Application No: BE/149/20/PL
Site Address: 339 Chichester Road Bersted PO21 5AN
Description of works: Replacement of blockwork boundary wall with fence & new vehicular access. This site is in CIL Zone 4 (Zero Rated) as other development.

Thank you for your internet representation made on 13th January 2021 which has been recorded as an objection with the comments as follows:

SITE PLAN

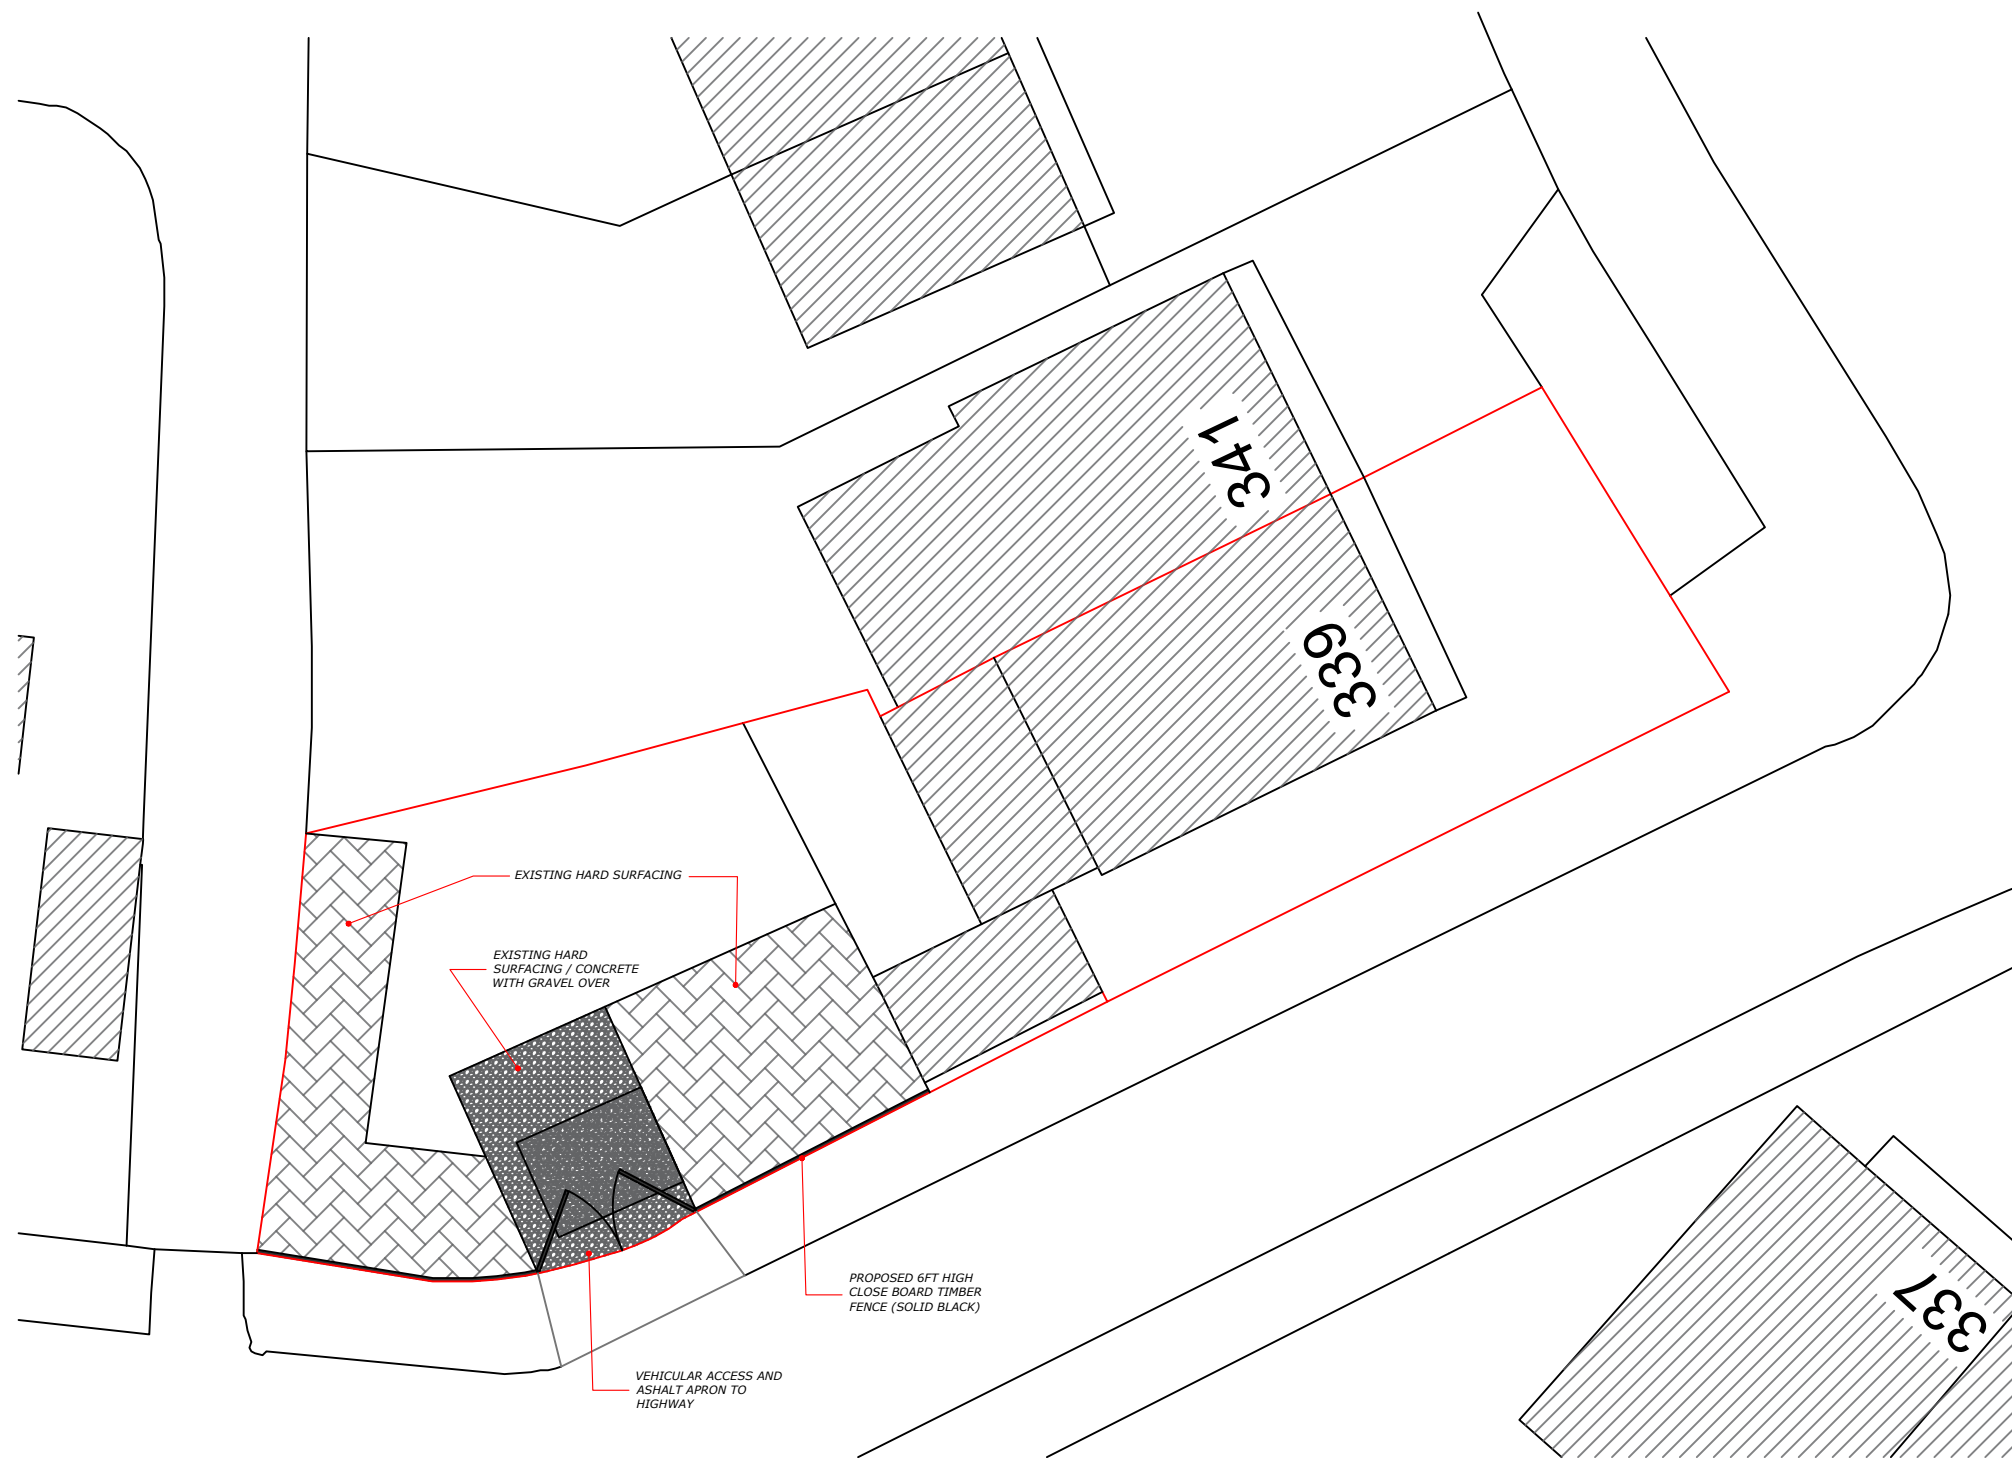
The visibility around that corner is abysmal. Bollards were put in place to prevent parking on the bend which is narrowed down to one vehicle width. I have been aware of emergency vesicles struggling to maneuver around that bend which endangers human life and well being. I have been aware of a plumbing business being run from that property with multiple vehicles coming and going to the storage at the property. The location of the drop Curb is located directly on the blind bend. The property already has a driveway at the front of the property accessible from Chichester Road so further access to a residential property for residential purposes should and must be questioned. Access directly on a corner is an unnecessary risk in this residential road
